CITY OF ALBUQUERQUE

Planning Department
David Campbell, Director

**RE: Smiles for Kids Dental Office – Phase 2
9211 Eagle Ranch Road NW
Permanent C.O. – Not Accepted
Engineer's Certification Dated 06/27/18
Engineer's Stamp Date: 07/21/17
Hydrology File: C12D055**

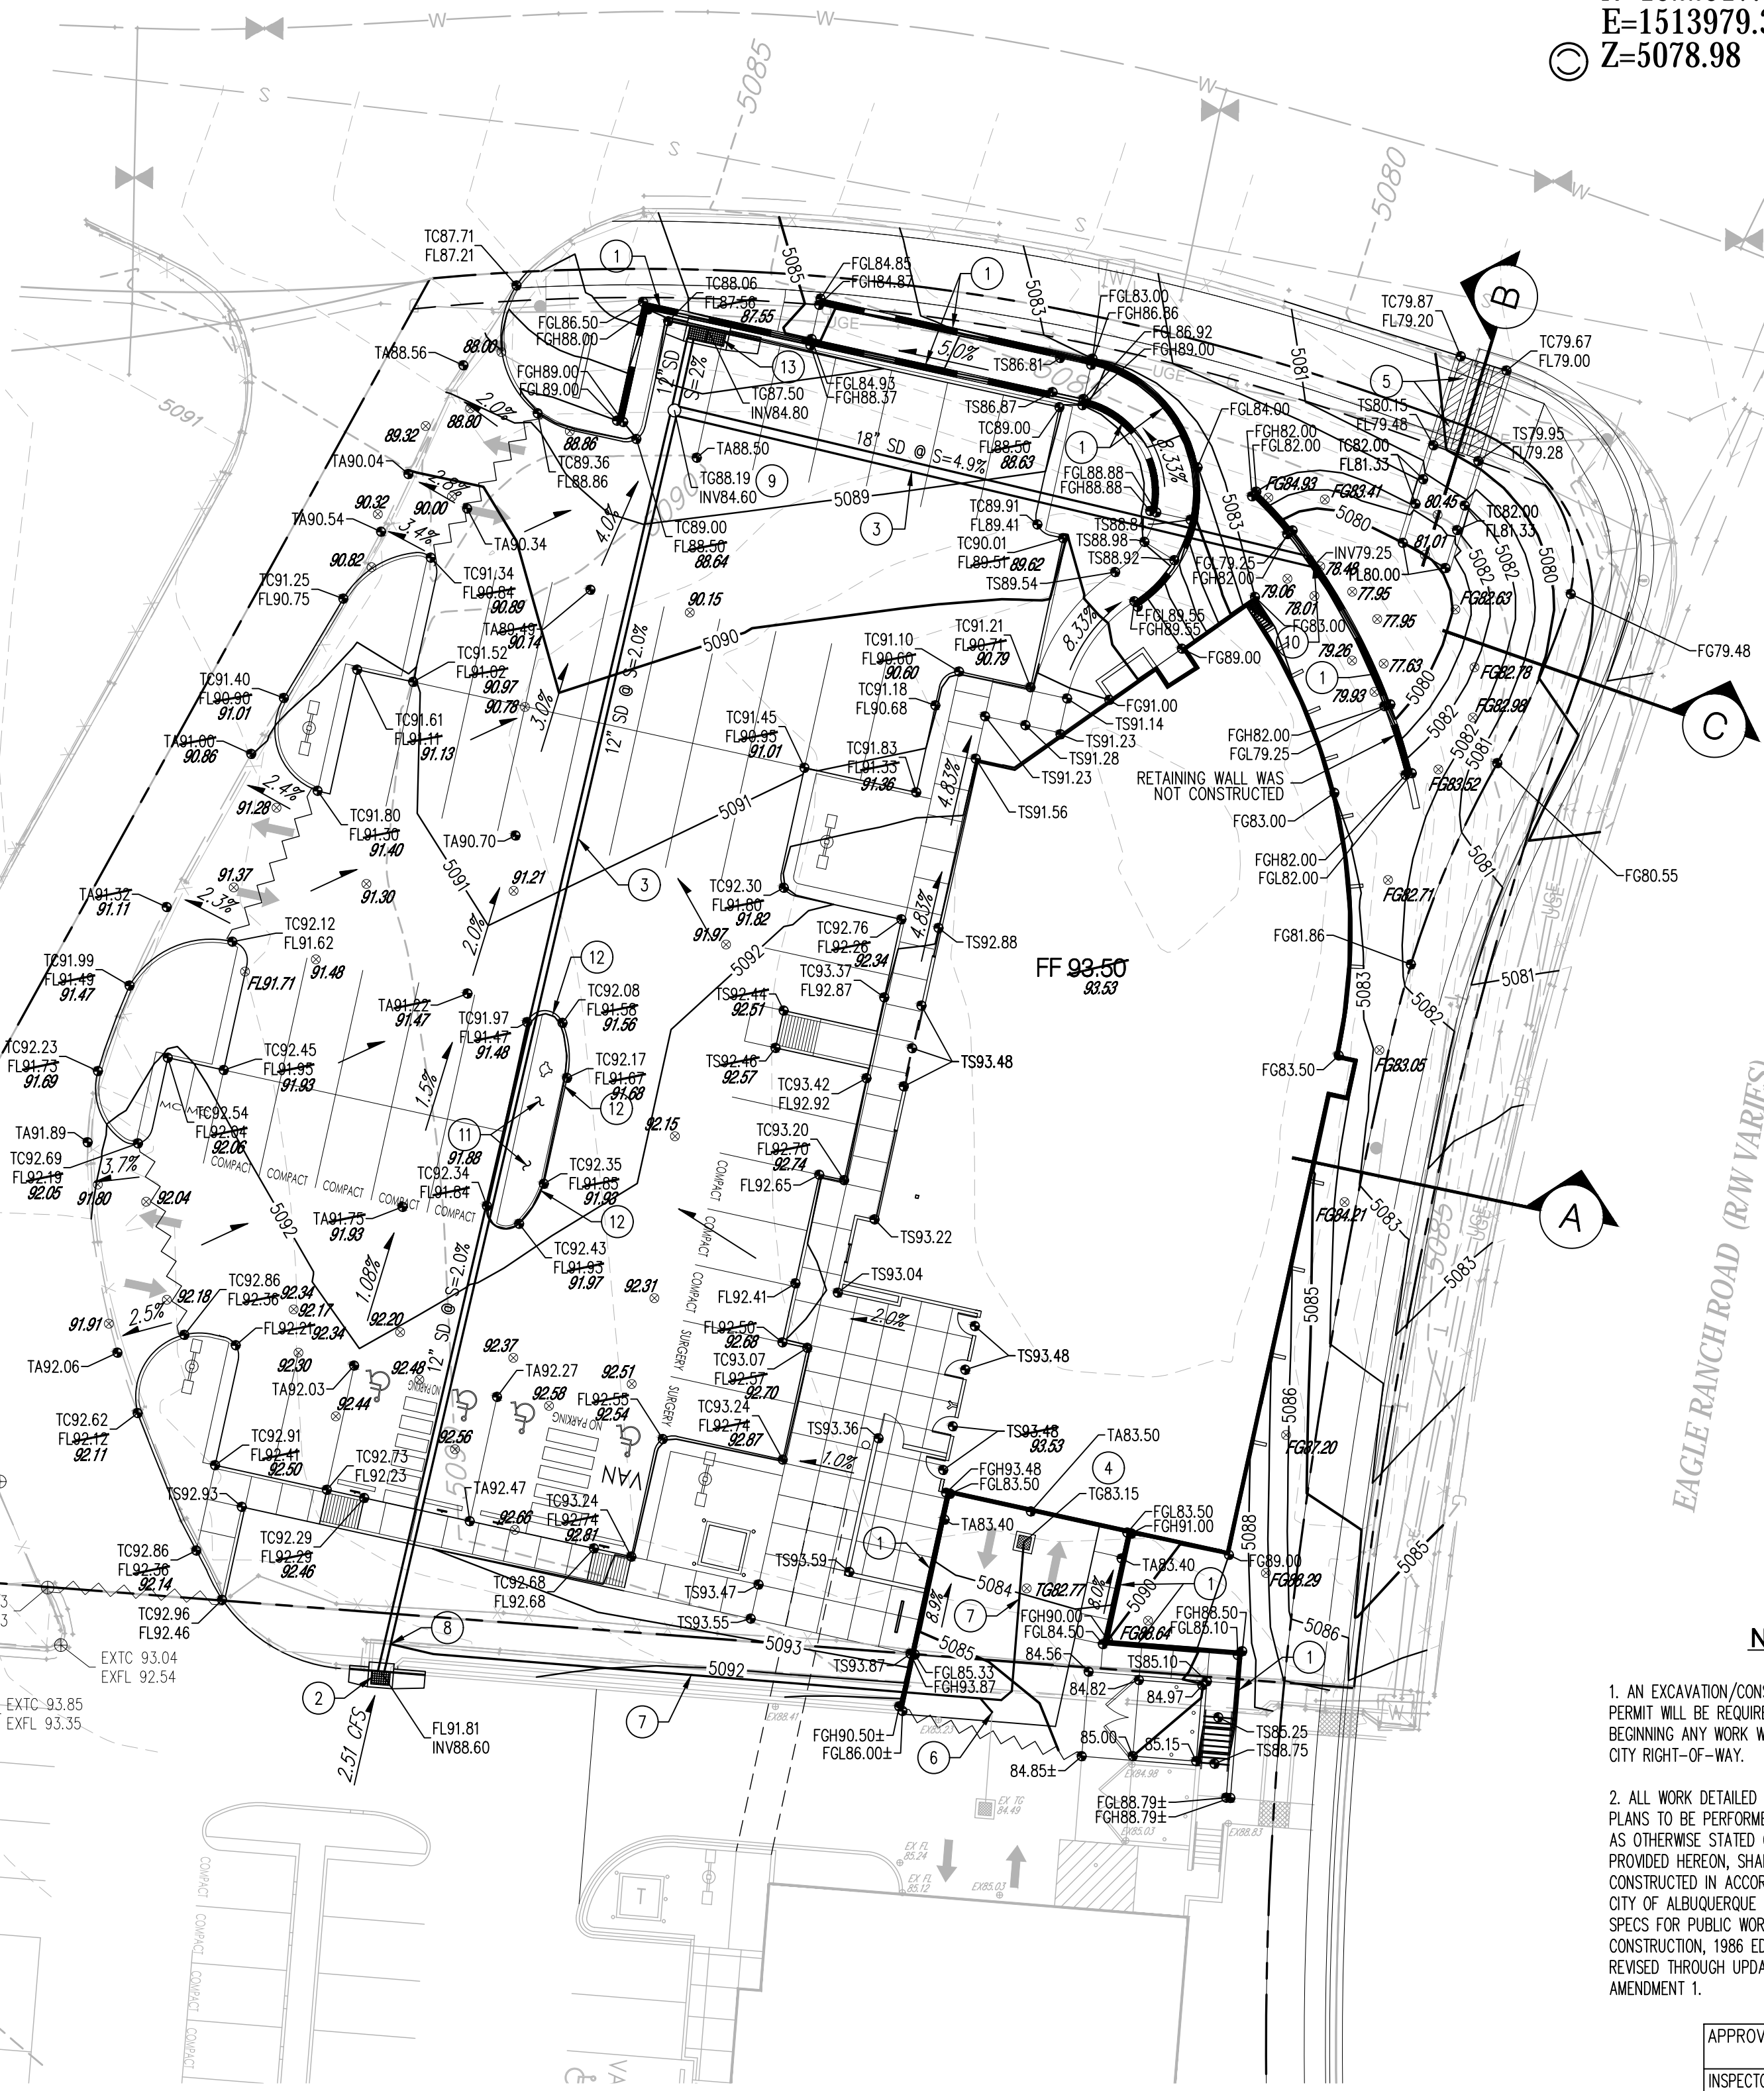
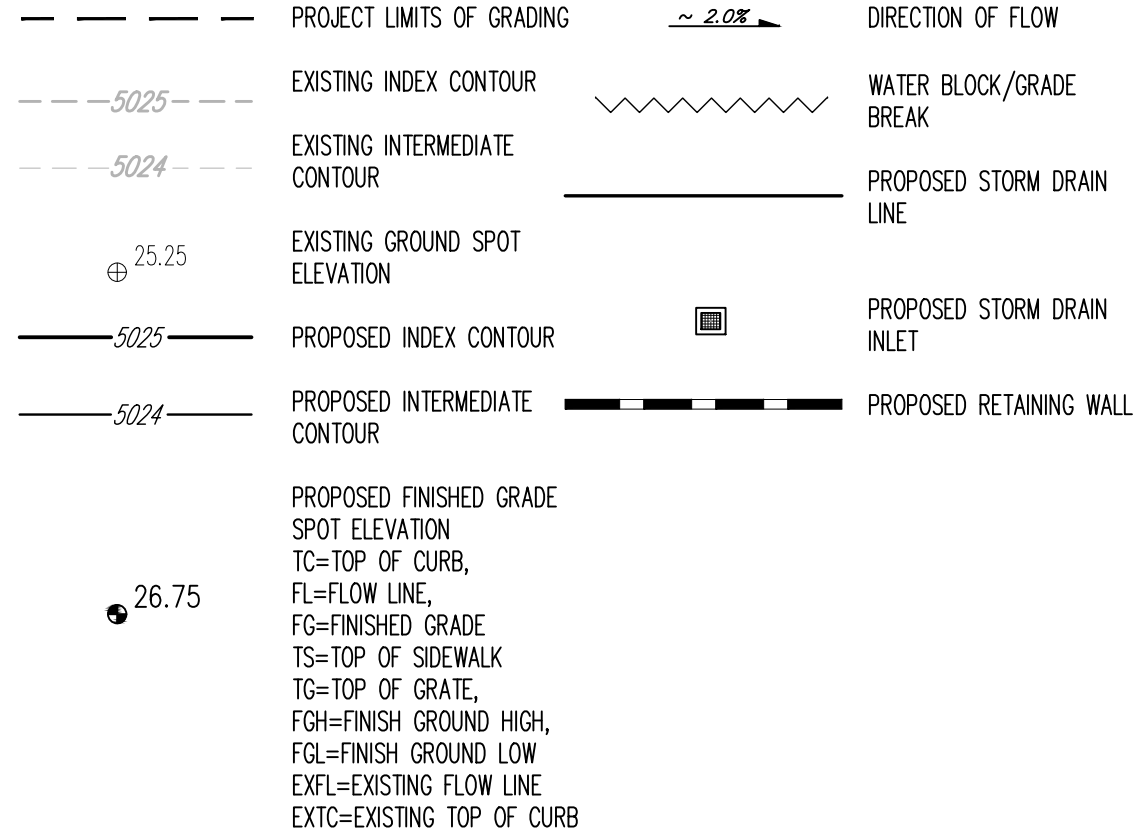
2. Since the built first flush pond only provided 738 CF of the required volume of 950 CF, a Fee in Lieu is going to be required for the difference in required first flush volume of 212 cubic feet. The Fee in Lieu payment (**Amount = 212 CF x \$8/CF = \$1,696.00**) for this difference in required first flush volume must be made using the attached City of Albuquerque Treasury Deposit form. The Owner needs to bring three copies to the cashier on the Building Permits side of the ground floor and pay the fee. Once this is done, please provide Hydrology with one of the copies showing the receipt.

3. Please provide a Private Facility Drainage Covenant per Chapter 17 of the DPM for first flush pond prior to Permanent Release of Occupancy. Please submit this on the 4th floor of Plaza de Sol. A \$25 fee will be required.
